OFFICIAL NOTIFICATION OF DECISION

Project# PR-2019-002284
Application#
SD-2023-00033 PRELIMINARY/FINAL PLAT
SD-2023-00035 VACATION OF PUBLIC STORM
SEWER EASEMENT
SD-2023-00036 VACATION OF PRIVATE
DRAINAGE EASEMENT

For all or a portion of: **PARCEL B-1-A
CORRECTION PLAT OF PARCELS C-1-A, V-1-B
and B-1-A, RENAISSANCE CENTER III** zoned
NR-C, located at **1500 DESERT SURF CIRCLE
NE** containing approximately **9.2281** acre(s).
(F-16)

PR-2019-002284_February_8_2023 - Notice of Decision

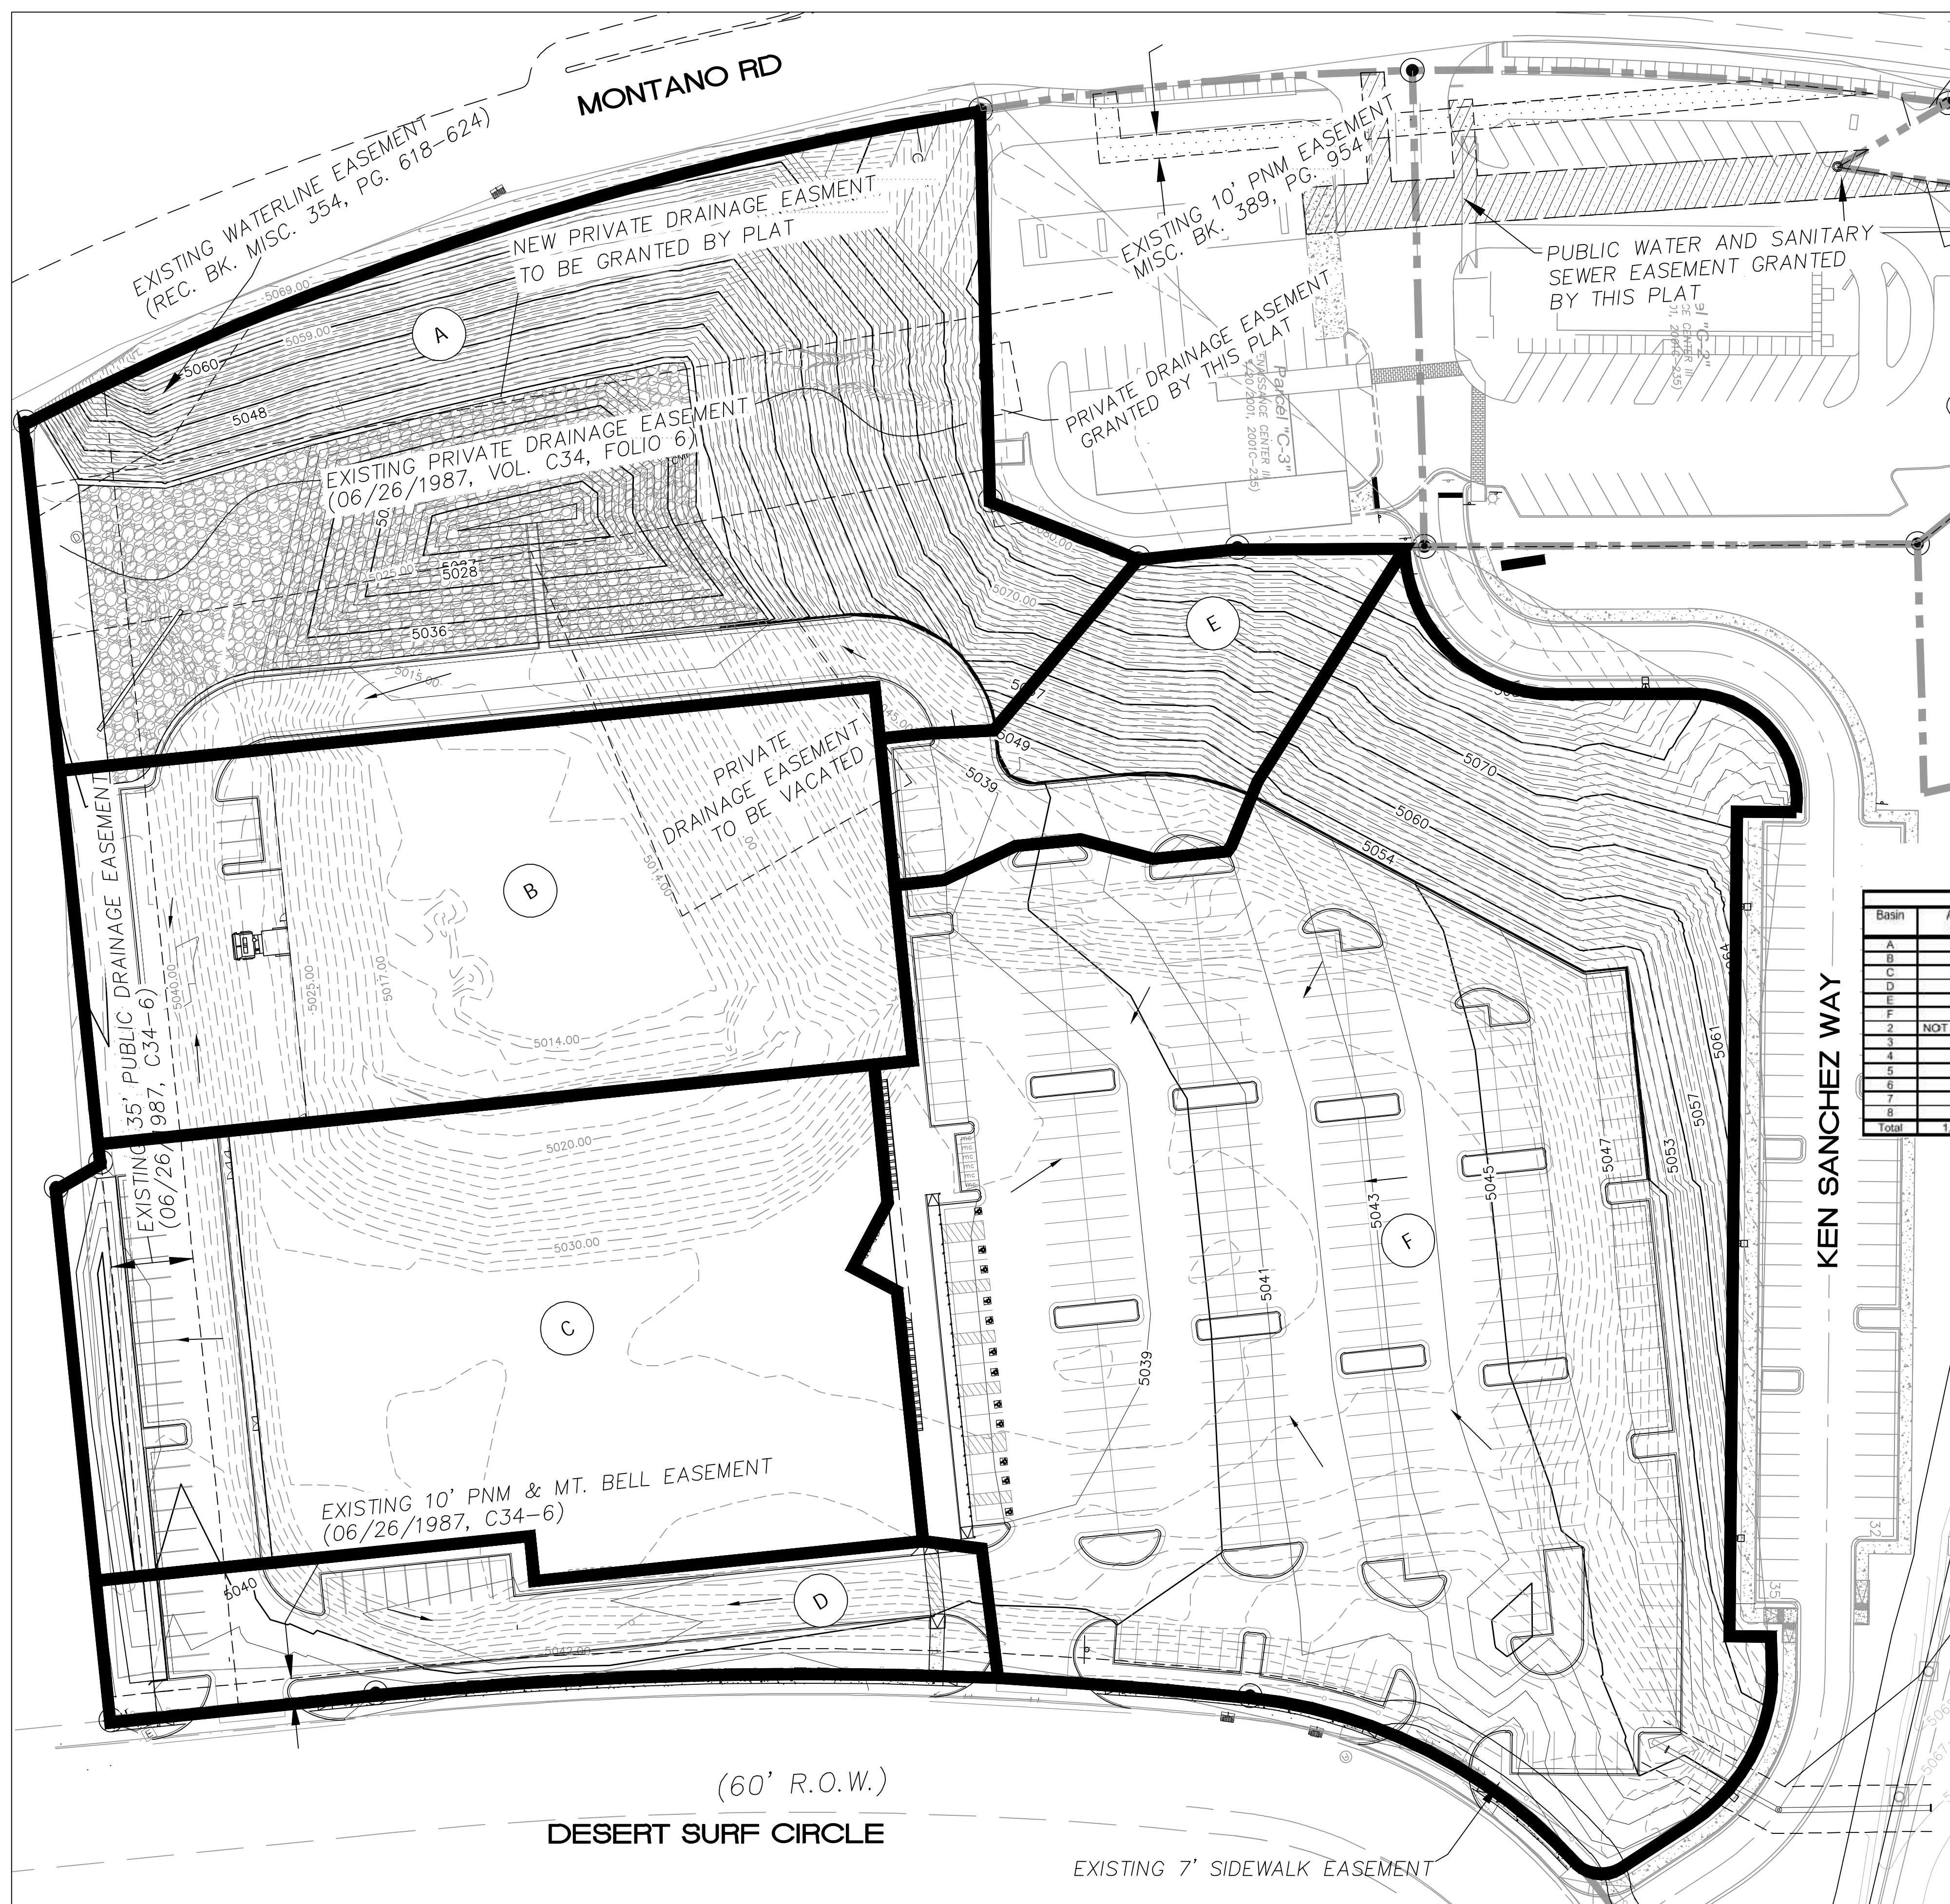
- a. The applicant must address street trees along Montano Rd. NE with the Site Plan.
- b. On the Plat, the applicant must remove the DRB reference on the Planning signature line and add a signature line for Hydrology.

Plat of
Parcel B-1-A-1
Renaissance Center III
Elena Gallegos Grant
Projected Section 34, Township 11 North,
Range 3 East, N.M.P.M.
Albuquerque, Bernalillo County, New Mexico
November 2022

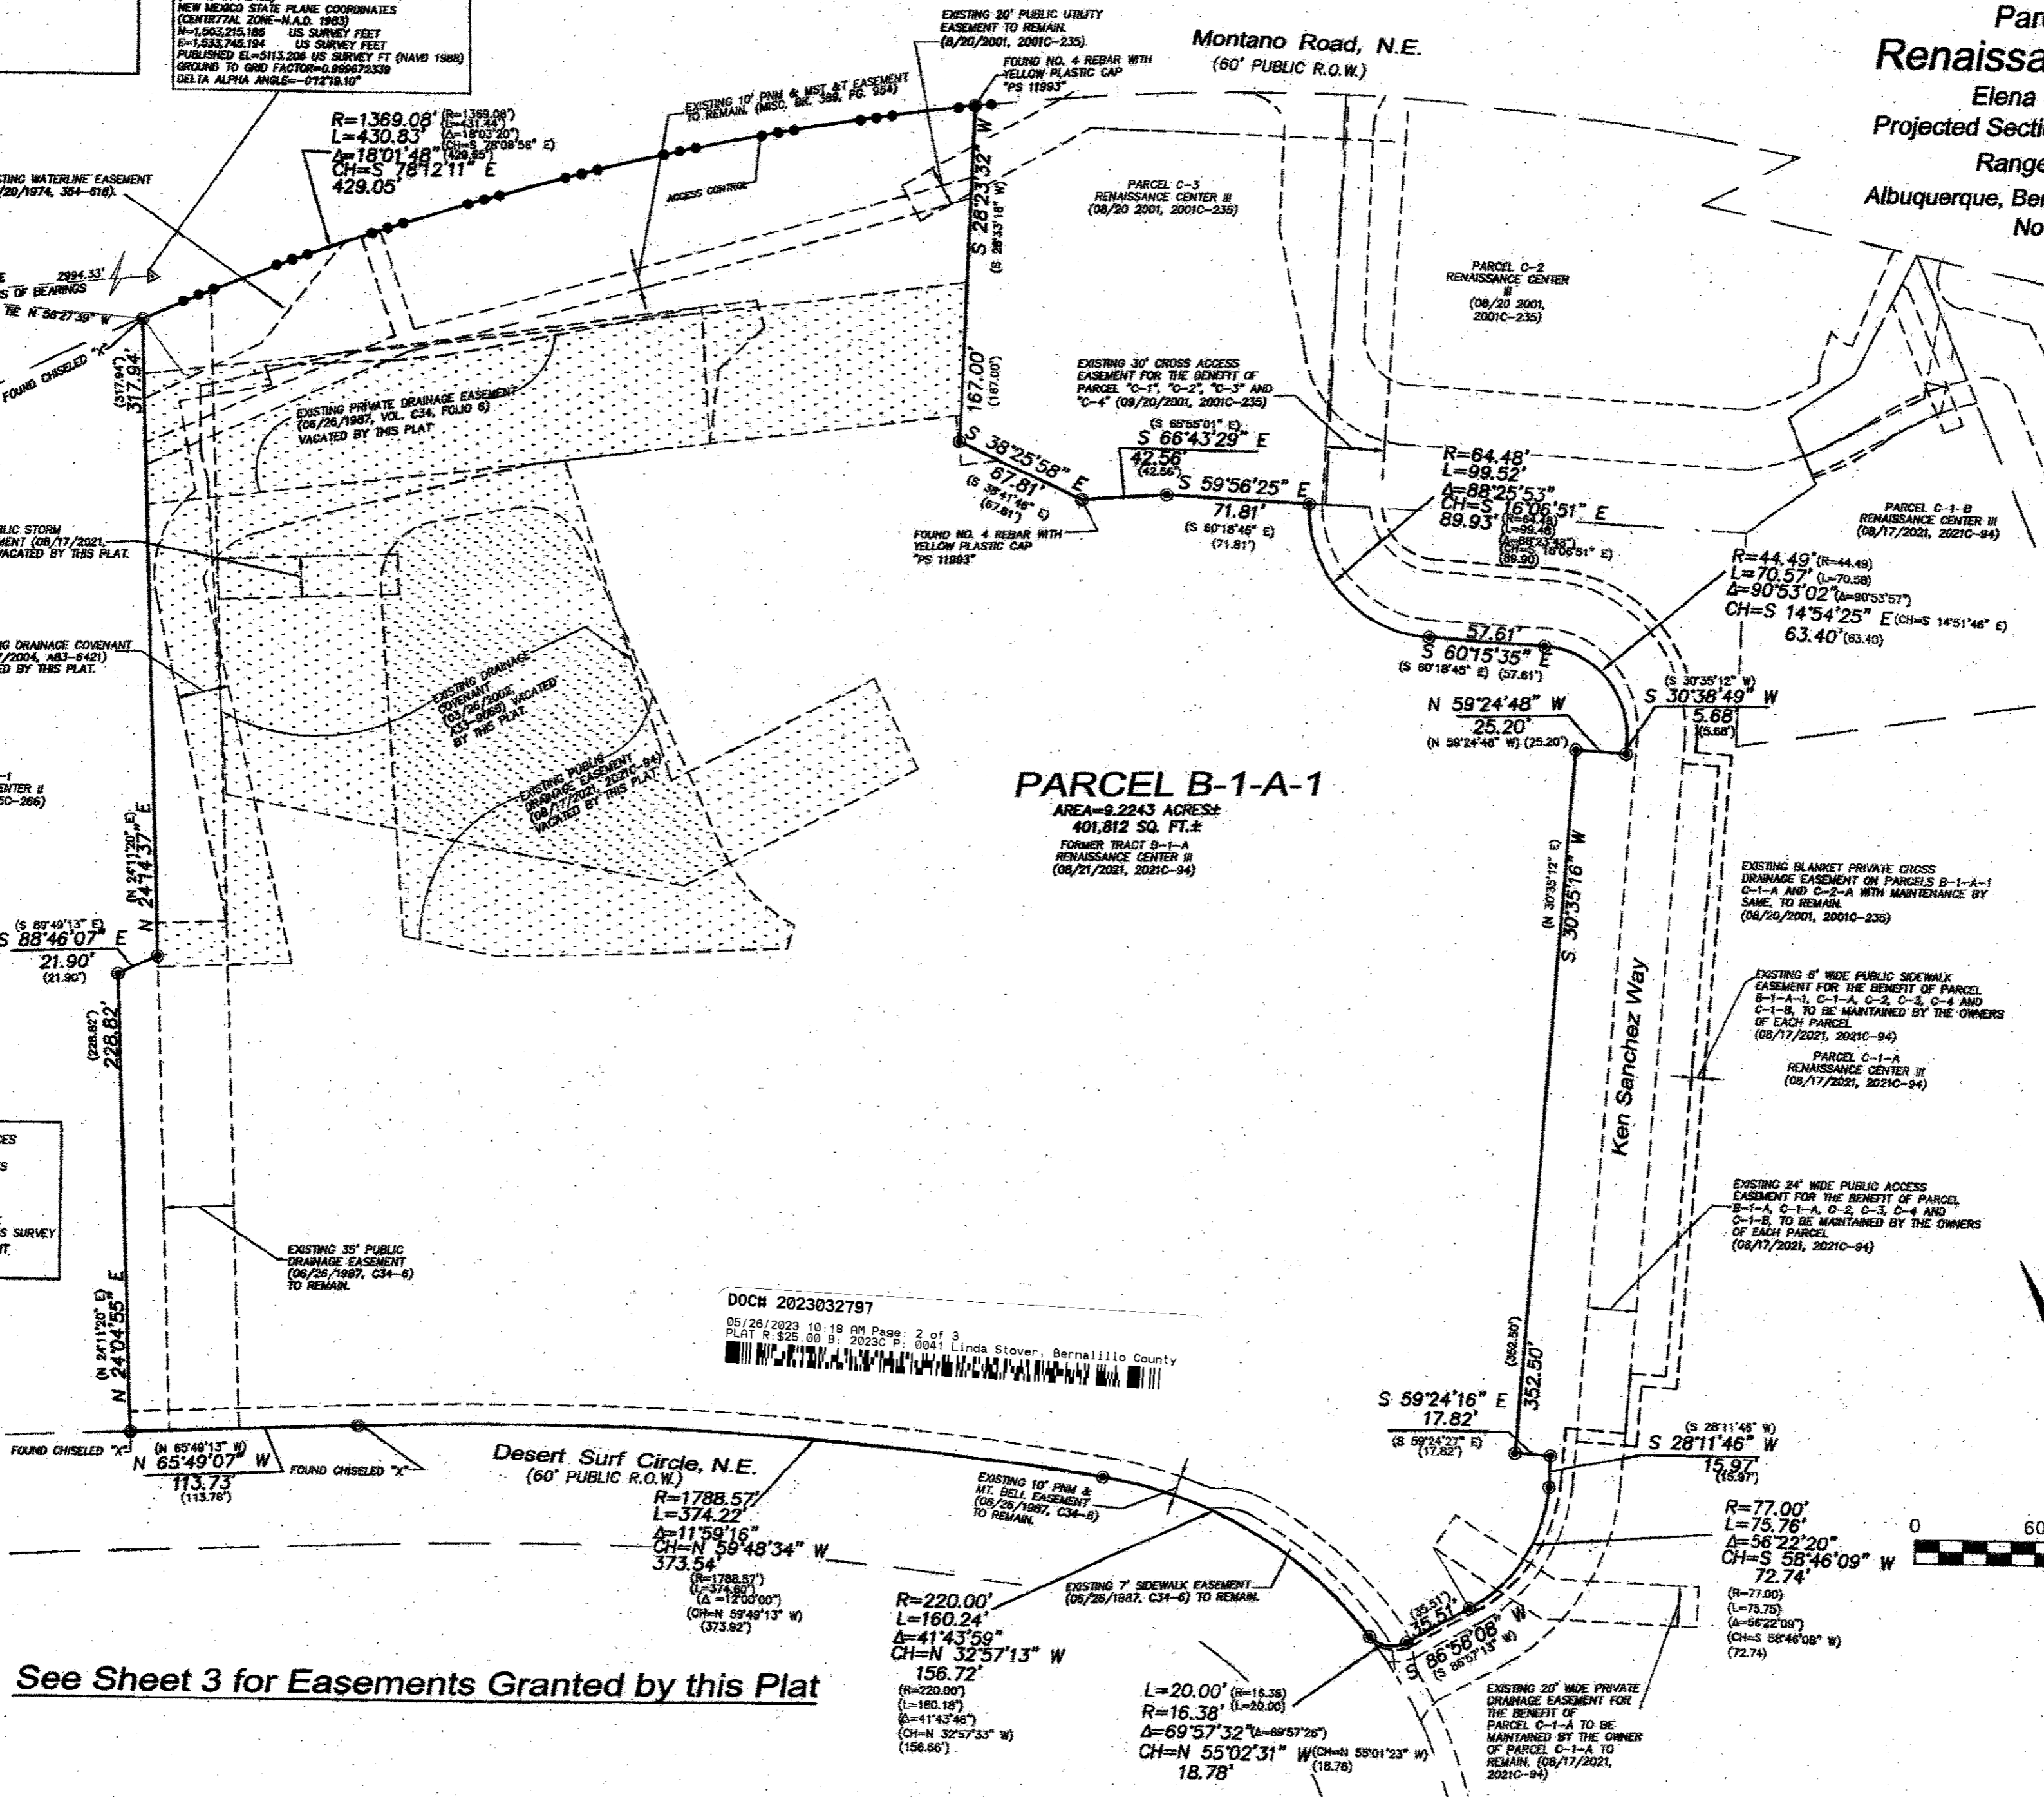
1. The applicant proposes to vacate an existing public storm sewer easement recorded on August 17, 2021.
2. The applicant justified the vacation request for the easement pursuant to 14-16-6-6-(M)(3) of the IDO. The existing storm sewer easement was set up to accept storm water from water from other parcels that made up The Beach Water Park and have changed over the years to accommodate the redevelopment of the property. The reduction of the storm sewer easement to a smaller area continues to accept upland flow and to protect the public and minimizes the amount of area needed for the drainage to function. This reduction does not negatively impact the existing drainage system which will continue to function as it does today.

1. The applicant proposes to vacate an existing private drainage easement recorded on June 26, 1987.
2. The applicant justified the vacation request for the easement pursuant to 14-16-6-6-(M)(3) of the IDO. The existing drainage easement was set up to accept storm water from water from other parcels that made up The Beach Water Park and have changed over the years to accommodate the redevelopment of the property. The reduction of the drainage easement to a smaller area continues to accept upland flow and to protect the public and minimizes the amount of area needed for the drainage to function. This reduction does not negatively impact the existing drainage system which will continue to function as it does today.
